RE: RIO GRAND TITLE COMPANY PARKING LOT (J18-D1A). GRADING AND DRAINAGE PLAN FOR PAVING PERMIT. ENGINEER'S STAMP DATED AUGUST 20, 1997.

Based on the information provided on your August 20, 1997 submittal, City Hydrology has the following comments:

RIO GRANDE TITLE GRADING & DRAINAGE PLAN

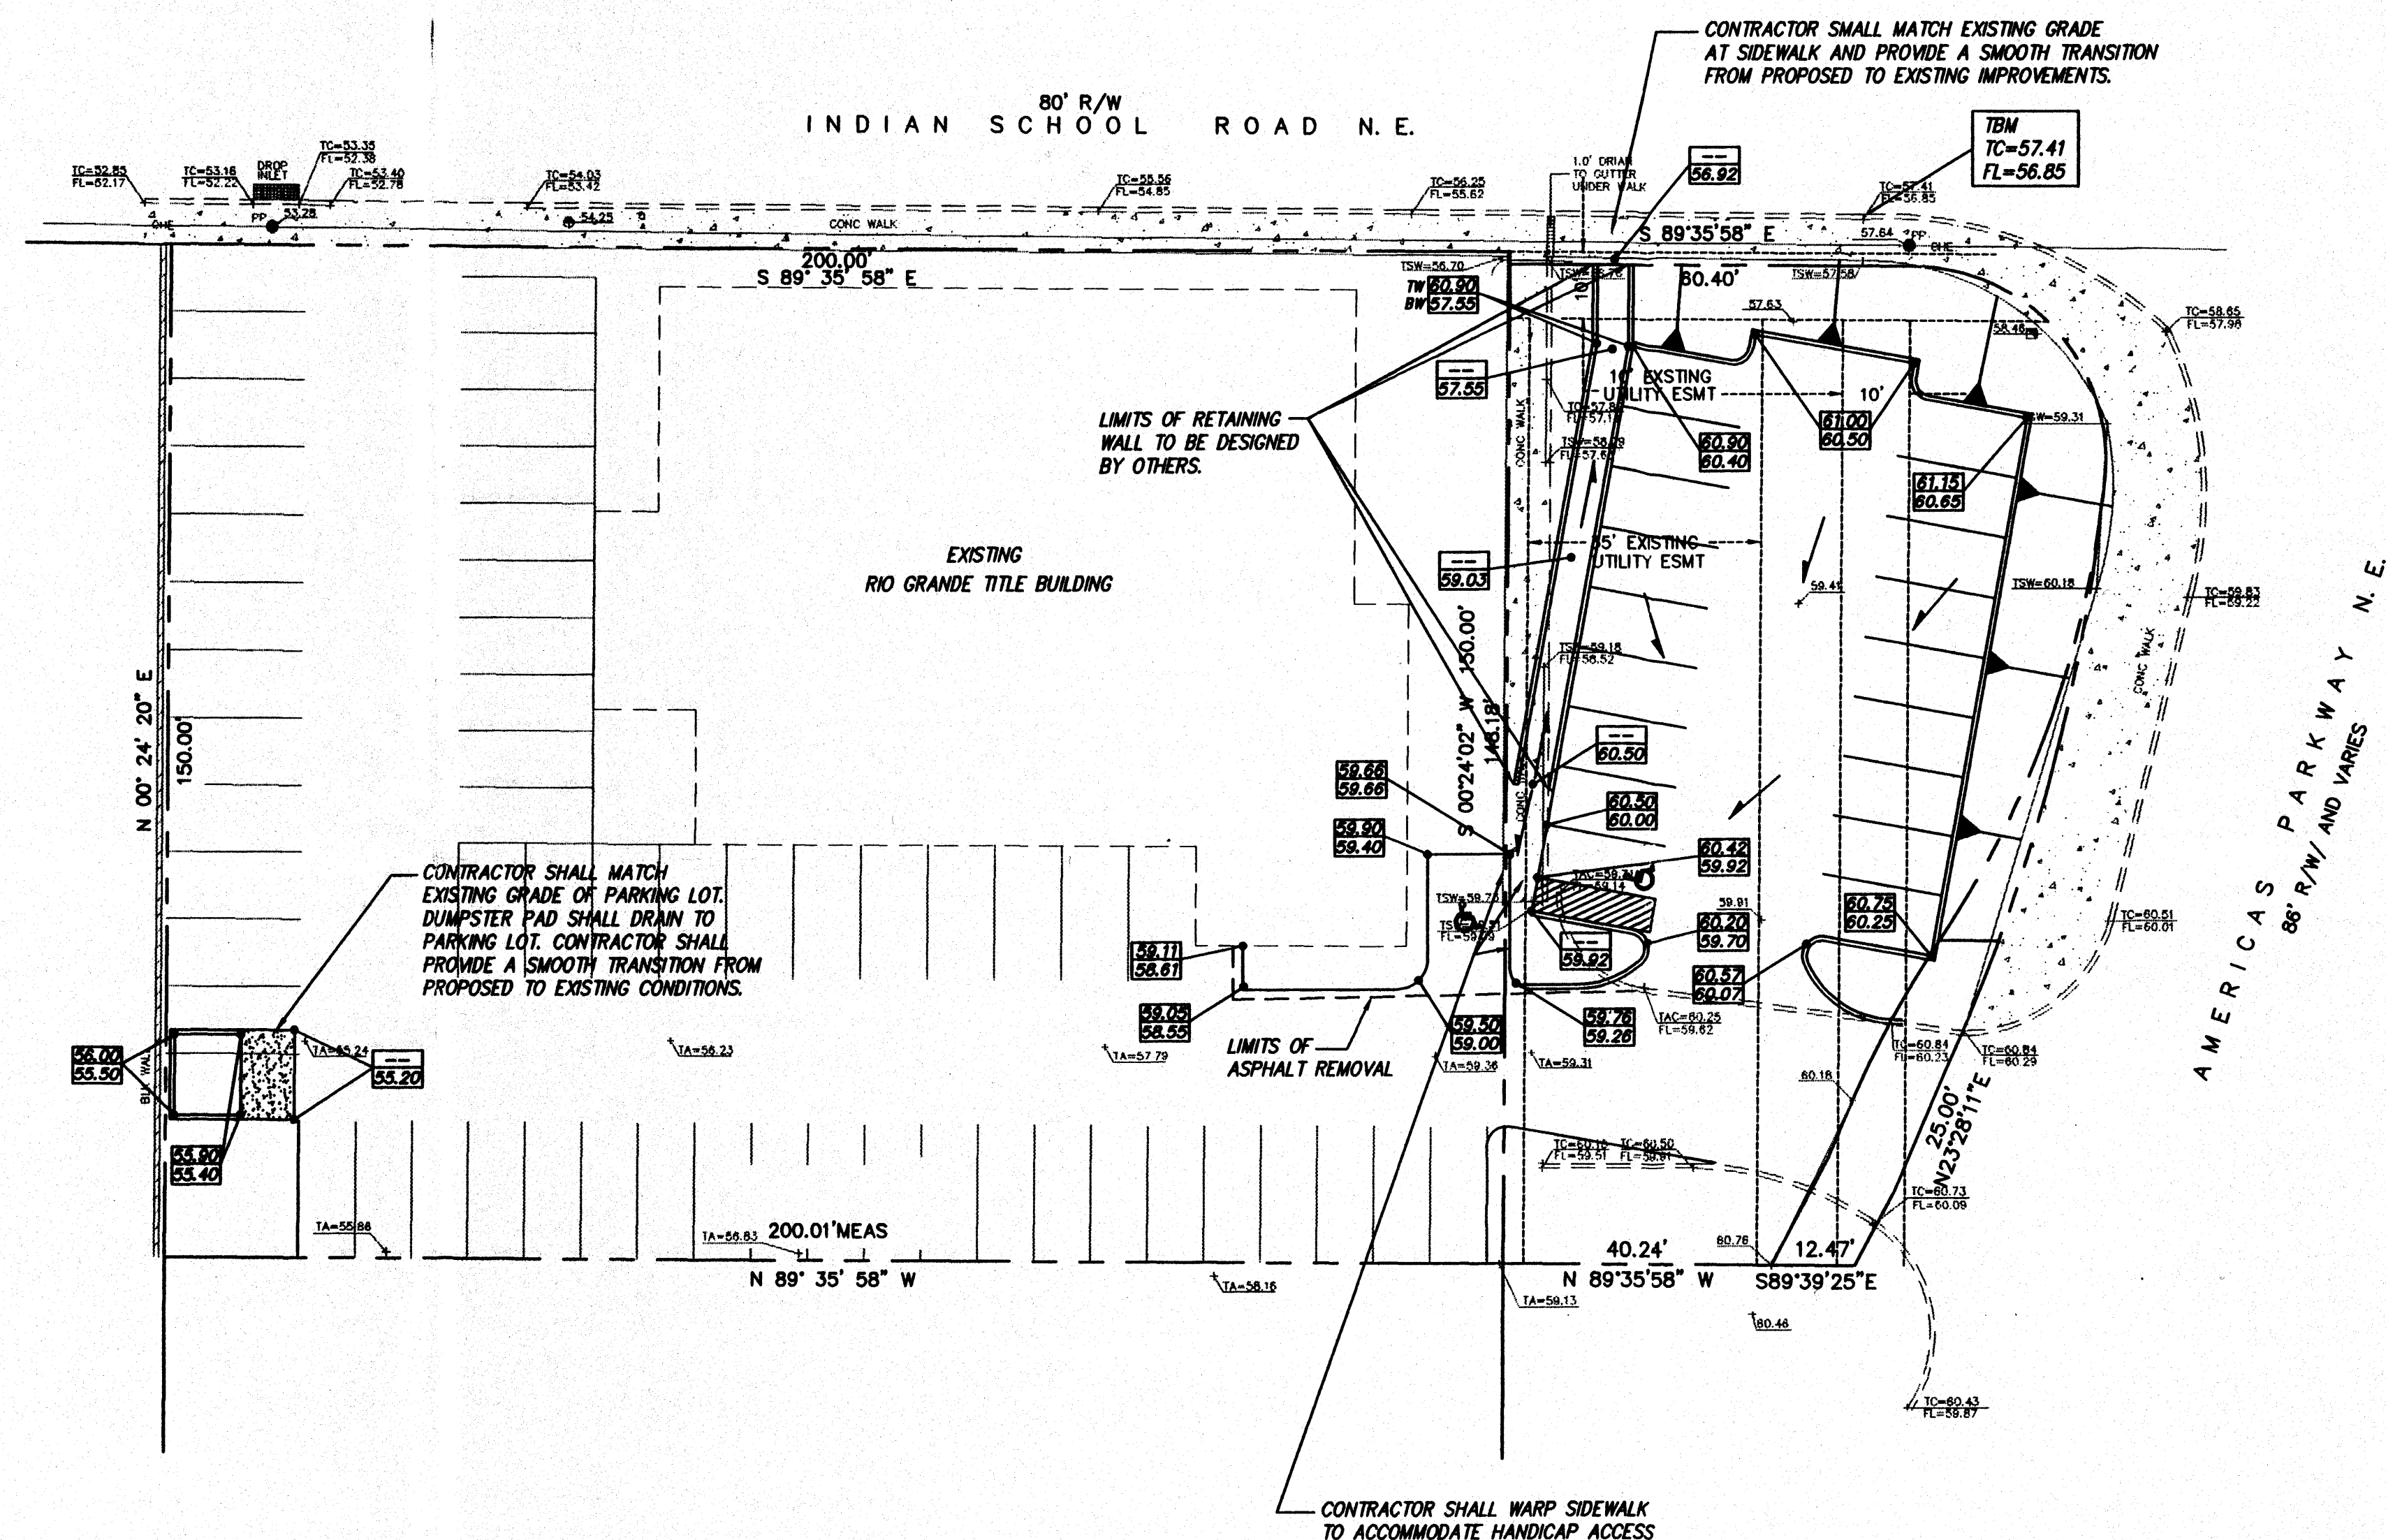
1. It appears that some flow from this site is directed over the sidewalk (area between retaining wall). A sidewalk culvert and SO #19 permit will be required.
2. Is the area between the retaining walls concrete?
3. Provide existing contours. I can follow the flow pattern to the trash enclosure. Where does the flow exit the site?
